PERMIT ISSUED		CBL: <i>216</i>
Permit No: 02-0834	Issue Date: 7/7/2002	017 E015001

This is to certify that Connolly Michael C &/Portland Builder
has permission to Addition of 4th Floor Living Space/Interior Renovation
AT 36 Waterville St Call 017 E015001

17 E015) Building Permit #020834

To: Steve Thomas
CC:
From: Mike Nugent/Manager of Inspection Services
Date: 09/03/2002
Re: 36 Waterville St. (017 E015)

7.01.03 ROOF MODIFICATIONS  
 revisions  
 date  
 MAY, 2002  
 sheet title  
**SITE INFO SECTION**

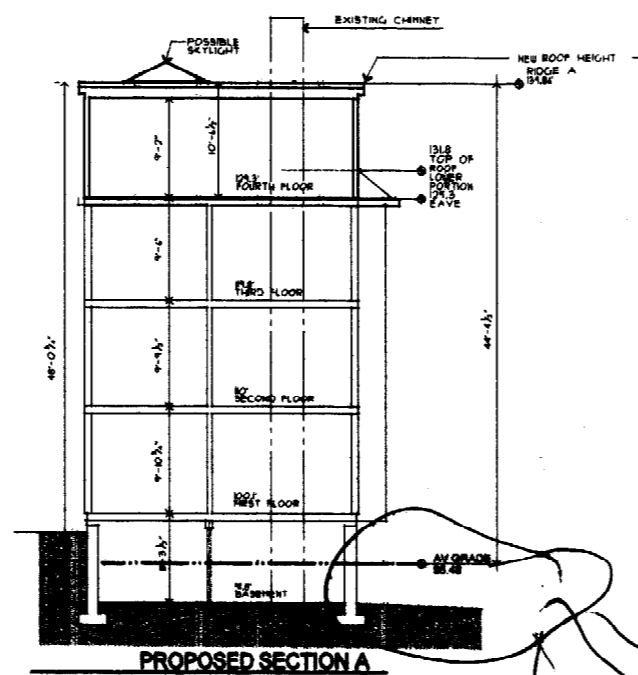
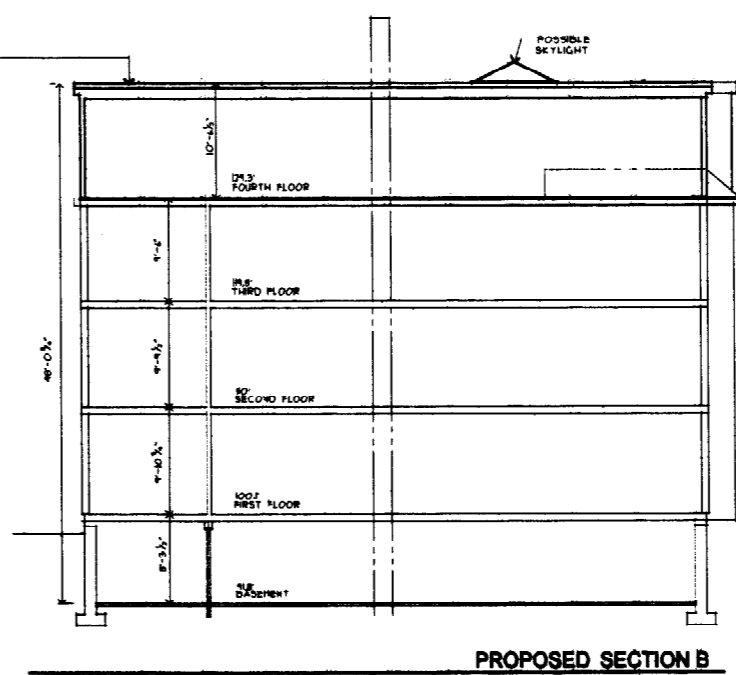
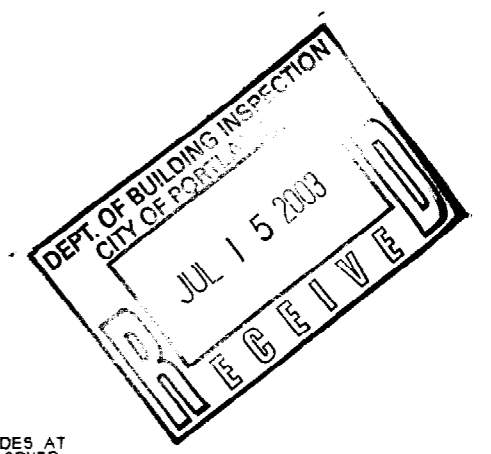
- 1)The openings on the north elevation must be limited to 10%. Because this is an NFPA 13R system, the code considers the openings unprotected and limited to 10%.
- 2)The Guards must be redesigned as the mesh has an ornamental pattern.
- 3)The owner agrees to install the NFPA type 13R system in the forth floor immediately and retrofit the entire building within 24 months of the issuance of a certificate of occupancy.
